CITY OF ALBUQUERQUE

November 3, 2014

**RE: Estates at Glendale Unit 2
Drainage Report and Grading and Drainage Plan
Engineer's Stamp Date 10-13-14 (File: B19D027)**

10/13/14

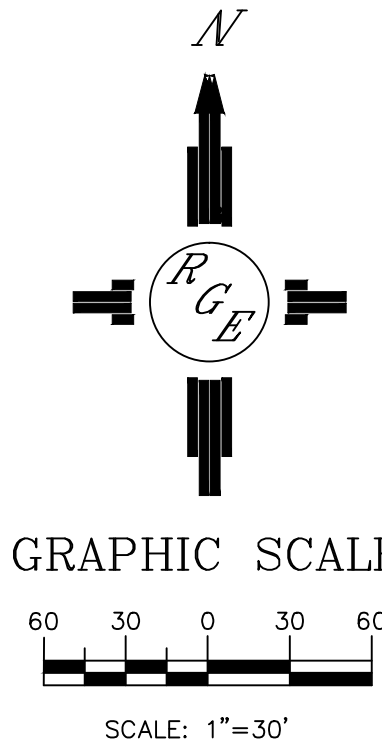
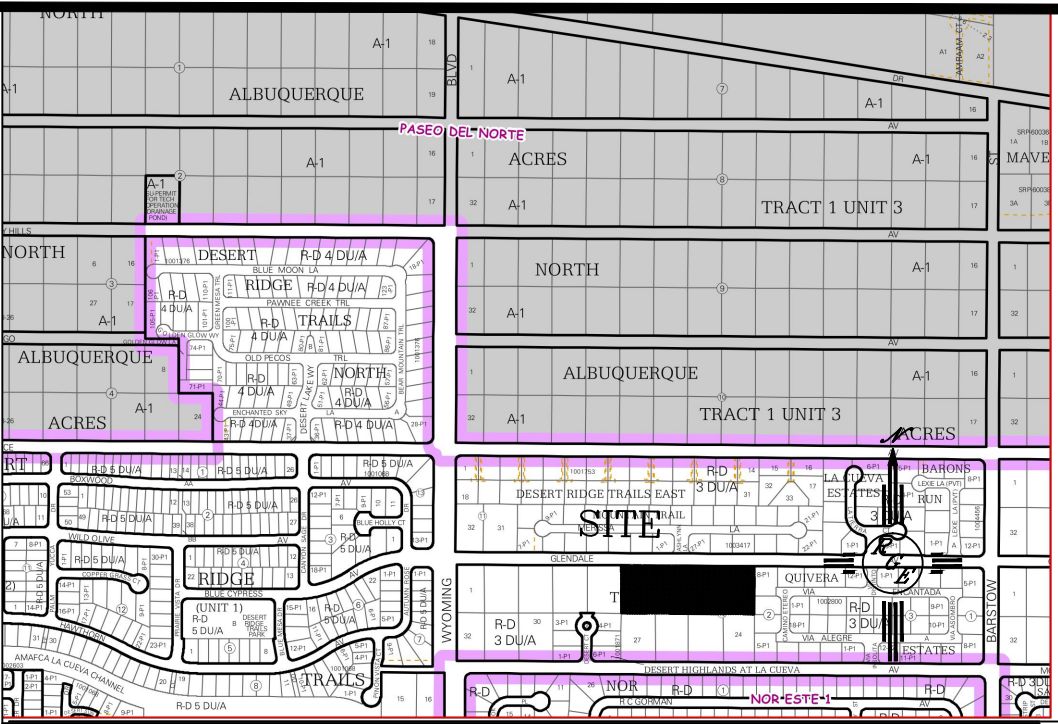
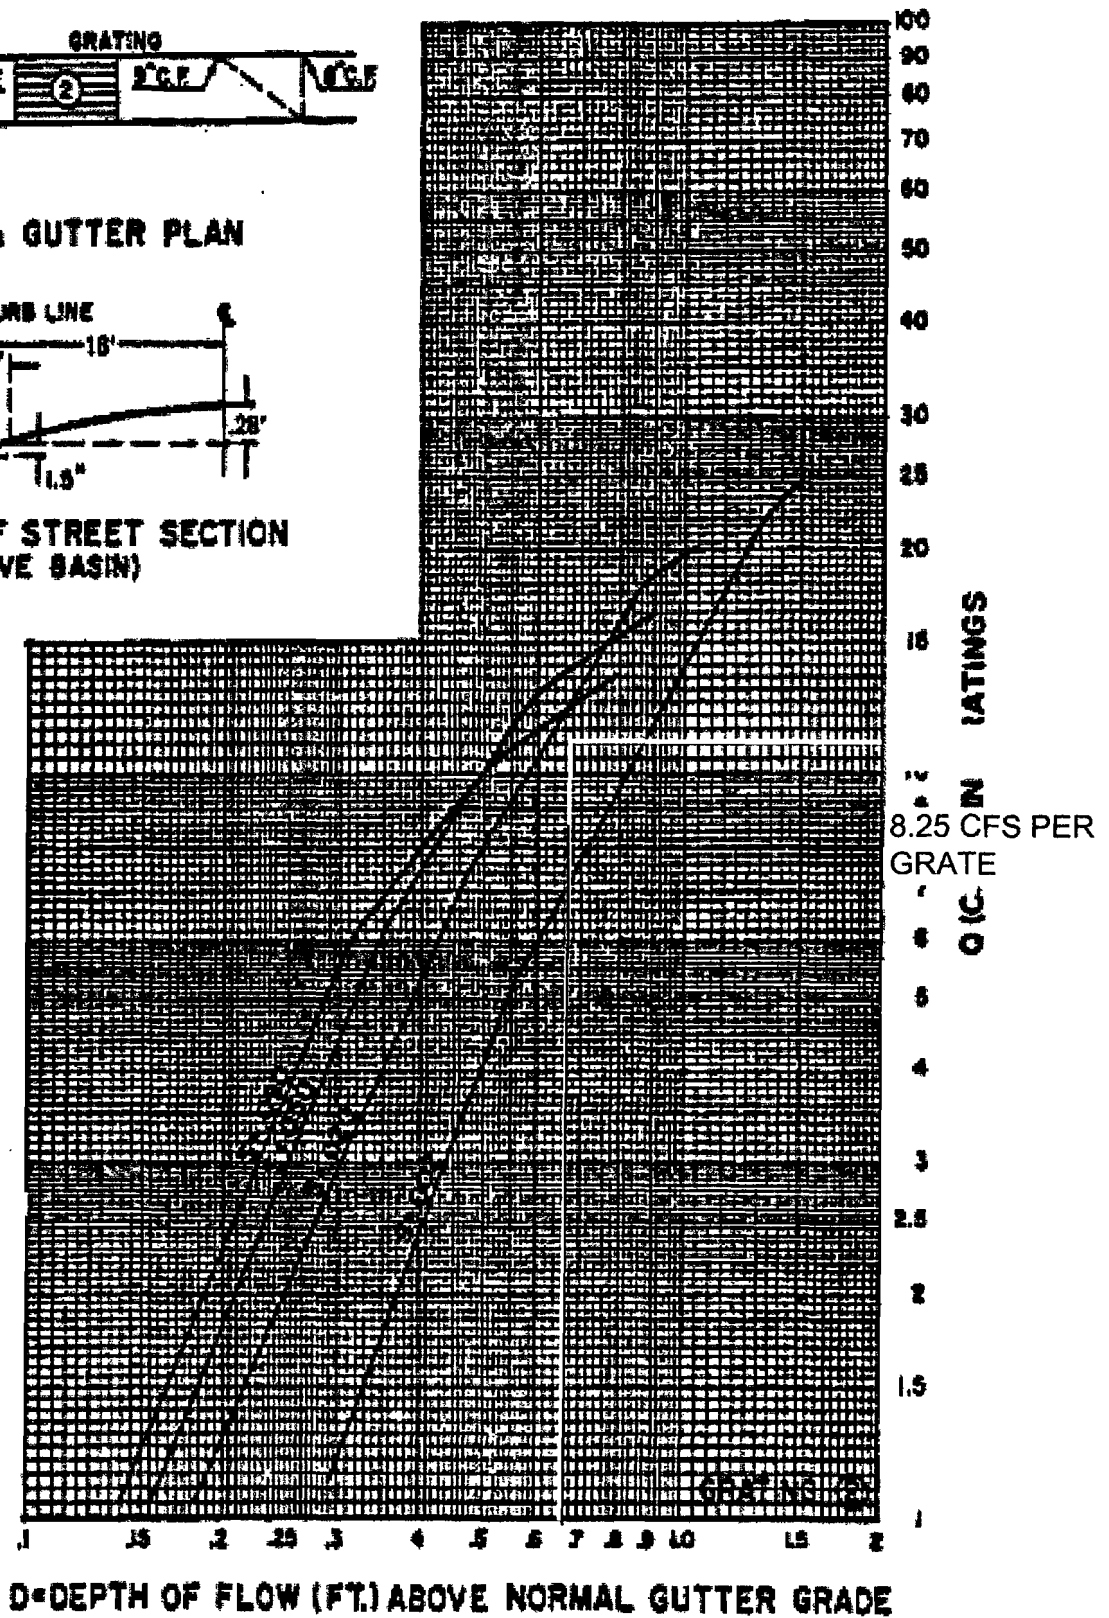
1. Concrete channel in SW corner needs to be shown on plan and PDE on plat.
2. Existing contours are barely visible
3. Land treatments of offsite basins use 43% Treatment A, which is for undisturbed by human activity. Aerial views show that these lots are graded and landscaped and I believe should be more along the lines of treatments used in the NAADR, or 20% A, 20%B, 34% C, and 26%D, resulting in a total runoff similar to that in the Drainage Report by Mark Goodwin and Assoc.

4. Approvals from owners are required prior to providing openings in existing block walls.
5. The amount of offsite flows from the south thru each lot needs to be quantified, the location of each opening, and flow arrows indicating how the drainage passes thru each lot.

6. Offsite basin 104 from the Mark Goodwin Drainage Report drains thru a concrete channel in SW corner.
7. A drainage easement on east side of Lot 11 should allow offsite flows from Basin G to drain to North Star lane.

8. How is first flush handled? Drainage report indicates Storm Tech SC-740 Chambers, but are not shown on plan. First flush is captured by the "Isolator Row", which requires a woven fabric and inlet structure (manhole or Nyloplast drain basin) for clean out. Since this is a relatively new method of handling the First Flush, we should think about whether an inlet structure needs to be there and where it would be located on the site plan.

9. Scaling of areas shows land treatment D is about 58%, rather than 38% of total area for onsite basins.
10. Lots along west boundary should drain east to road, per the Mark Goodwin Drainage plan.

11. Street capacity and pipe calculations should be revised per the above comment and also to reflect greater flows from the revised land treatments.
12. The total runoff from this site and the offsite flows from the Mark Goowin report is 23.84 cfs. If the two inlets pick up 16.5 cfs, there is 7.3 cfs bypassing. Show street capacity calculations of Glendale to handle this additional flow. Show that downstream inlets have capacity.
13. Lot 14 does not have enough frontage for a drivepad on south side of inlet.
